Appeal Decision

Appeal Ref: APP/R4408/W/25/3361966

113 High Street, Dodworth, Barnsley, South Yorkshire S75 3RQ

- The appeal is made under section 78 of the Town and Country Planning Act 1990 (as amended) against a refusal to grant planning permission.
 - The appeal is made by Miss Robyn Dickinson against the decision of Barnsley Metropolitan Borough Council.
 - The application Ref is 2024/0548.
 - The development proposed is extension of an existing dropped kerb and the conversion of a front garden into a gated driveway.
-

PROPOSED SITE PLAN
SCALE 1/100

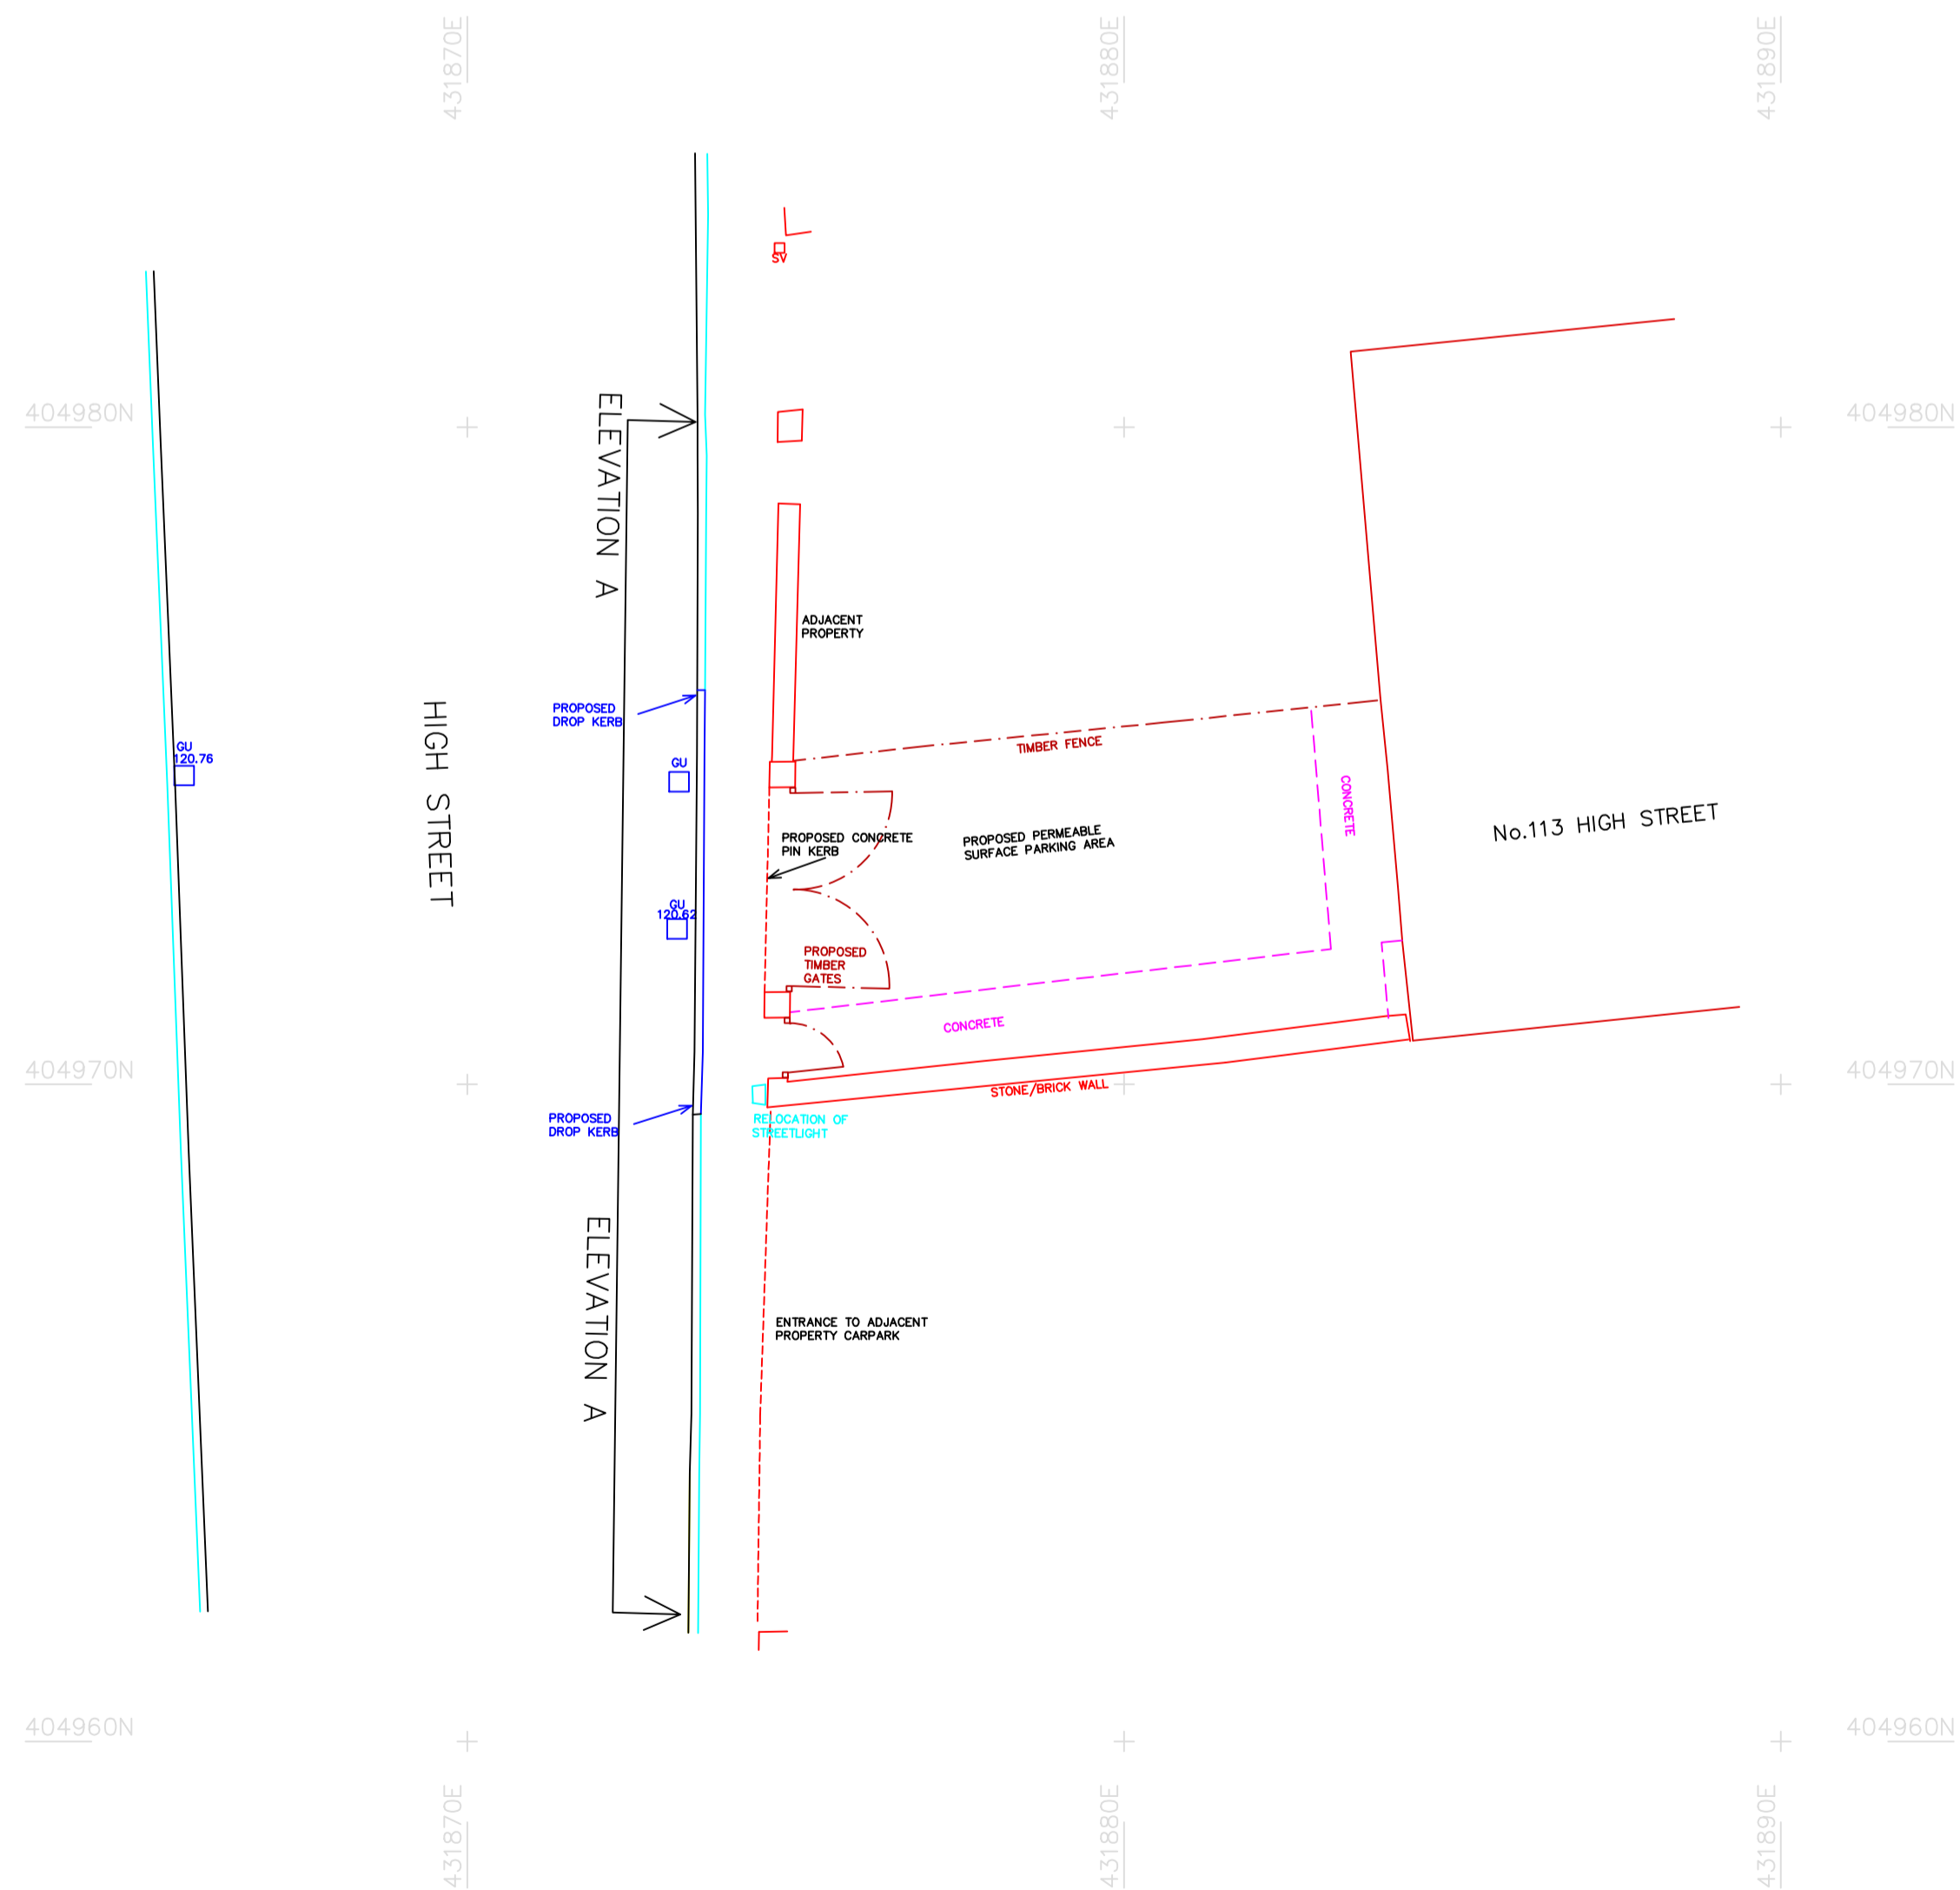
7. The size of the front garden area to the appeal property would not provide adequate space to allow a vehicle to manoeuvre within its boundaries to enter and exit in a forward direction. Therefore, vehicles would have to either reverse onto the proposed driveway, to exit in a forward gear, or reverse from the driveway onto the highway. Vehicles parked on the opposite side of the road would make manoeuvring onto and from the driveway more difficult. Furthermore, the proposed gates, while opening into the appeal property, would require a vehicle to stop on the highway to open them before manoeuvring onto the driveway.

8. Therefore, the proposal would result in oncoming vehicles, in both directions, having to contend with vehicles manoeuvring slowly onto or off the appeal property. As such, vehicles using the proposed driveway would increase incidents of other highway users having to slow rapidly or stop suddenly, particularly those travelling downhill, after the bend in the road and those users already negotiating vehicles parked on the roadside. As a matter of my planning judgement, the proposed development would result in greatly increased risk of conflict between road users and, thereby, substantially compromise highway safety.
